Dear Mr Crowther,

Unfortunately, the more I interrogate the data, the more questions arise, particularly in relation to the infiltration testing and the resultant resilience of the drainage system designed on the basis of those results. This has necessitated a further email.

Construction of SA1

Scale	Date	Designed
1:200 @A1	JUL 2025	AK
Drawn	Checked	Approved
AK	BO	BAC
Job No	Drawing No	Rev
21-254	21-254-701	D

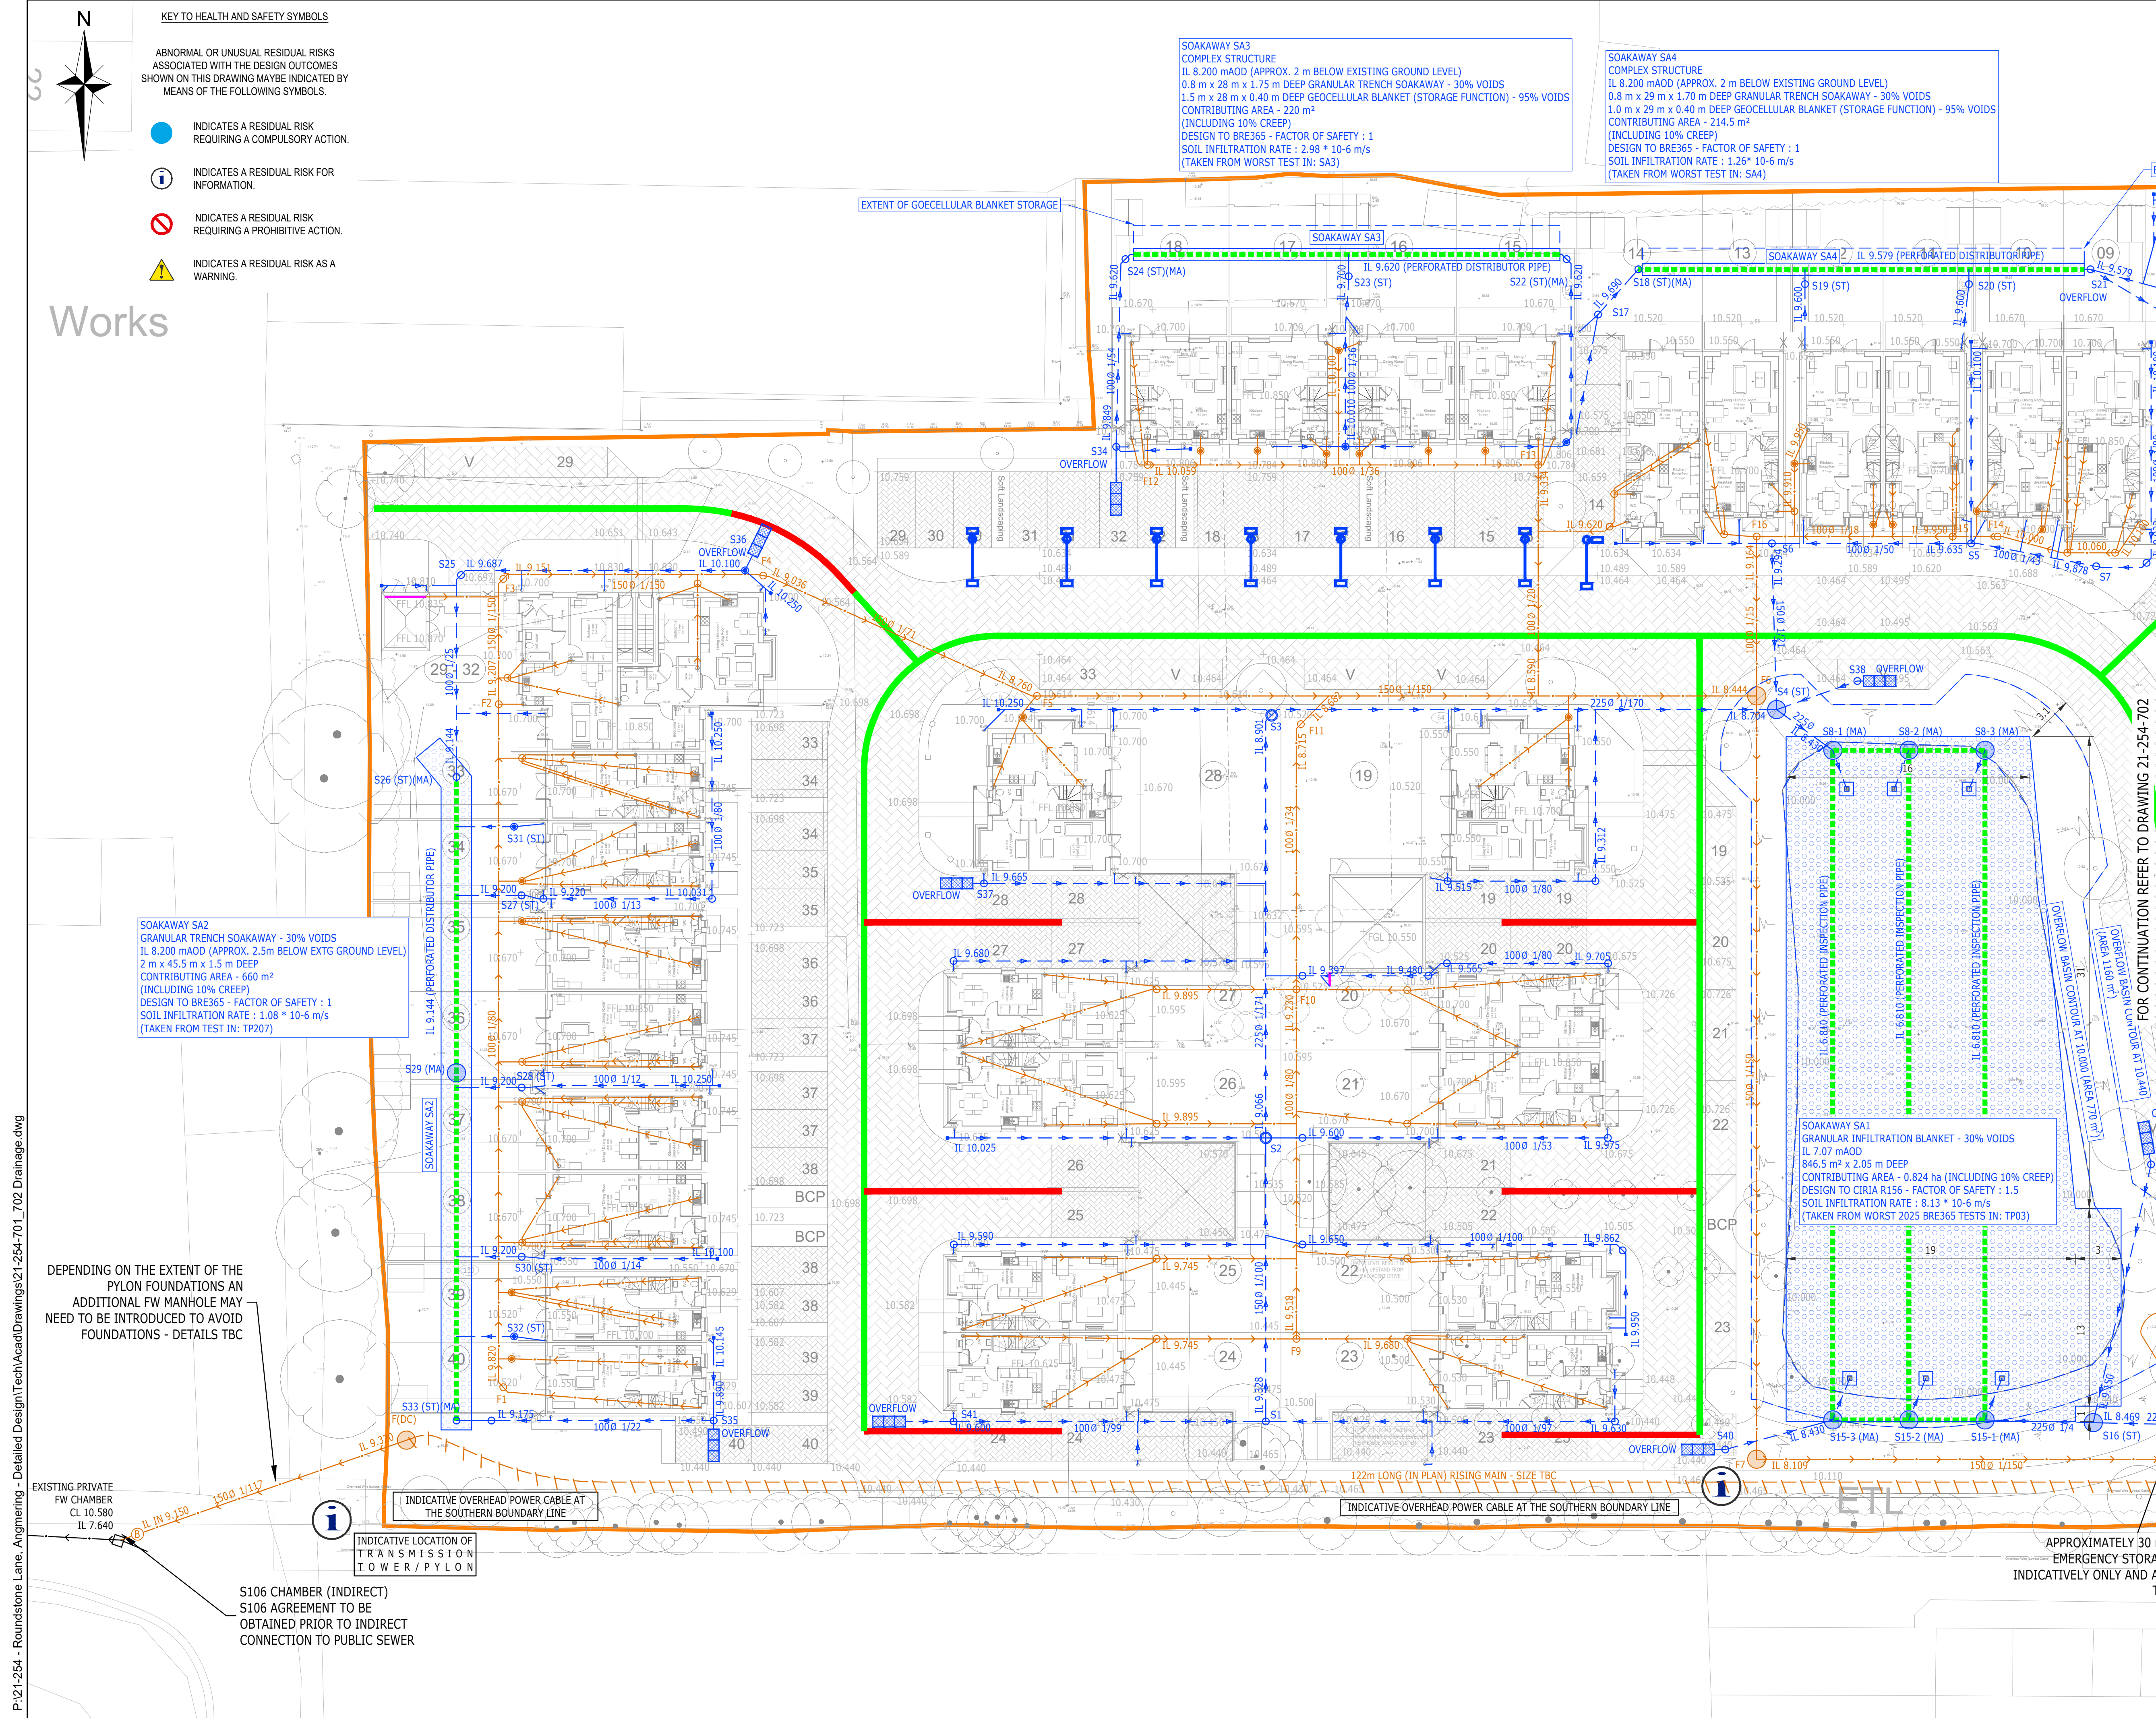
Let us consider the proposals for SA1 that have preceded this particular application, viz, the drawing which the applicant has presented as representing what was actually constructed on site:

This shows, clearly, a ground level of 10.000m AOD, an invert of 6.810m AOD and the top of the infiltration blanket at 8.660m AOD. This shows that the infiltration blanket should be encountered at 1.340 metres below the surface, and the membrane at the invert should be 3.190 metres below ground.

Depth Below Ground					
Drawing	21-254-502C	SA1	AOD	SA1	TP01	TP02	TP03	TP04
Ground level			10.000					
Top of infiltration blanket			8.660	1.340	1.700	2.000	2.000	1.500
Invert level			6.810	3.190	2.550	2.500	2.500	2.500

These logs all appear to indicate that SA1 was never constructed to the depth shown on the submitted drawing. It is also concerning that TP02 records membrane only at the invert, whilst TP03 records no membrane at all.

This also appears to imply that the infiltration blanket's thickness is as follows:

Note: Values in meters	TP01	TP02	TP03	TP04
Implied thickness	0.850	0.500	0.500	1.000
Designed thickness	1.850	1.850	1.850	1.850
Deficit	-1.000	-1.350	-1.350	-0.850

This means that, even had the earlier applications been approved, the soakaway as constructed would not have delivered the drainage system presented in the submitted drawings, with the resulting effect upon its long-term performance remaining unknown and the associated risk ultimately borne by the residents.

Out of interest, and referencing the proposed levels under application 7, it would appear that the invert of SA1 should now be 2.930 metres below ground, so the existing SA1 is still not deep enough, even if we discount the presence of foreign materials contrary to the specification.
